**Consultation Response from KC,
Highways Development Management**
2022/91880 The Richardson Arms, 684, Bradford Road, Oakenshaw, BD12 7EN
Erection of residential development
Date Responded: 7-9-2022
Responding Officer: Mark Berry
Responding Ref: 7-12NW-16

This application seeks approval to the erection of a residential development at The Richardson Arms, 684, Bradford Road, Oakenshaw.

This proposal includes the conversion of the former public house in 5 one bedroomed flats and the erection of a row of 5 two bedroomed town houses on the remaining land and car park.

| Proposed Site Plan |

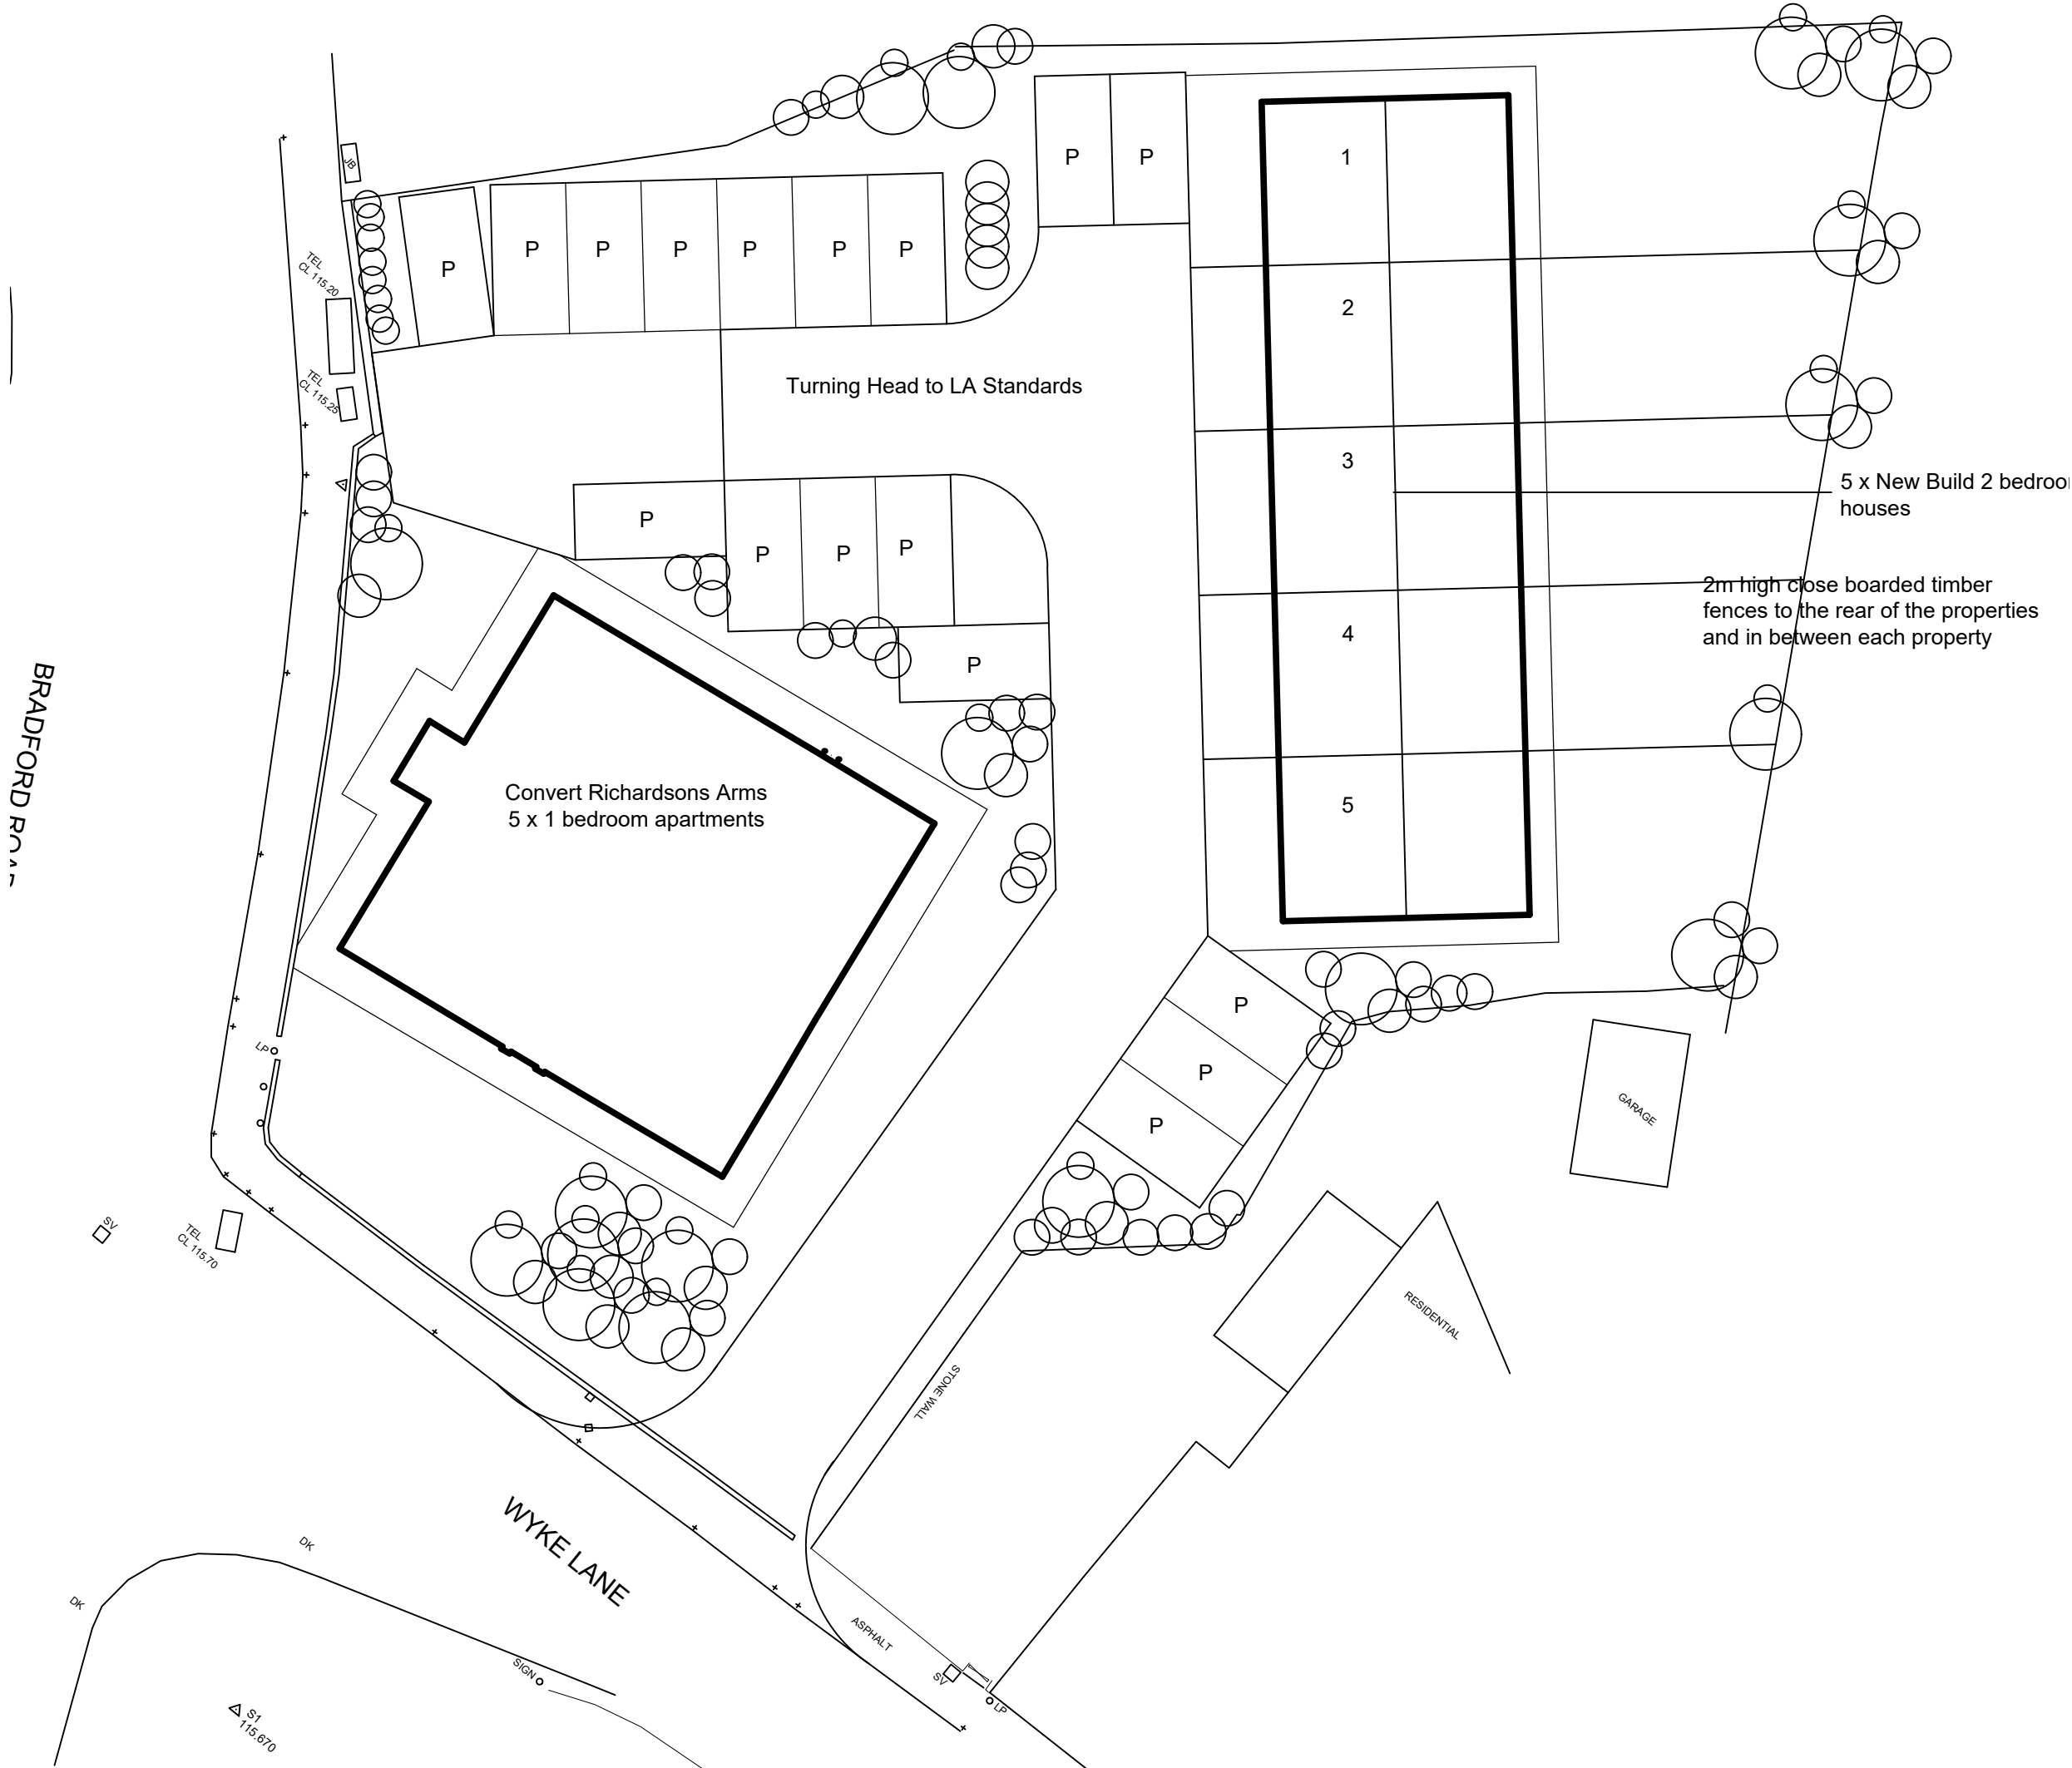
- 1, Can the applicants confirm their intentions regarding the adoption of the proposed access road. Is this access road to be a private driveway or adoptable shared surface. The layout as shown is not considered suitable for adoption.

- 2, There is over 45m from Wyke Lane to plot 1 and internal vehicle turning should therefore be provided for an emergency vehicle. This should be demonstrated using vehicle swept paths.

- 3, Details of waste collection proposals including storage and collection points should be provided. Note a refuse vehicle is unlikely to enter a private driveway.

- 4, The footway to the Wyke Lane frontage of the development should be widened to 2.0m to improve pedestrian access and secure sight lines from the proposed access onto Wyke Lane.

- 5, The parallel parking space to the north of the public house will be difficult to access and its location should be reconsidered.
- 6, The plans should identify which parking spaces, are for which plots, and which are visitor parking spaces.

- 7, The width of the access road and turning head should be increased to 6 metres to allow comfortable turning and manoeuvre into and of parking spaces.

- 8, The plans should be dimensioned for clarity.
- 9, Sight lines of 2.4m x 43m at the Wyke Lane/Bradford Road junction should be shown on the plans and the Bradford Road footway should be shown to be widened to accommodate these sight lines if

necessary.

10, The existing vehicular dropped crossing access on to Bradford Road should be shown to be closed and reinstated as footway.
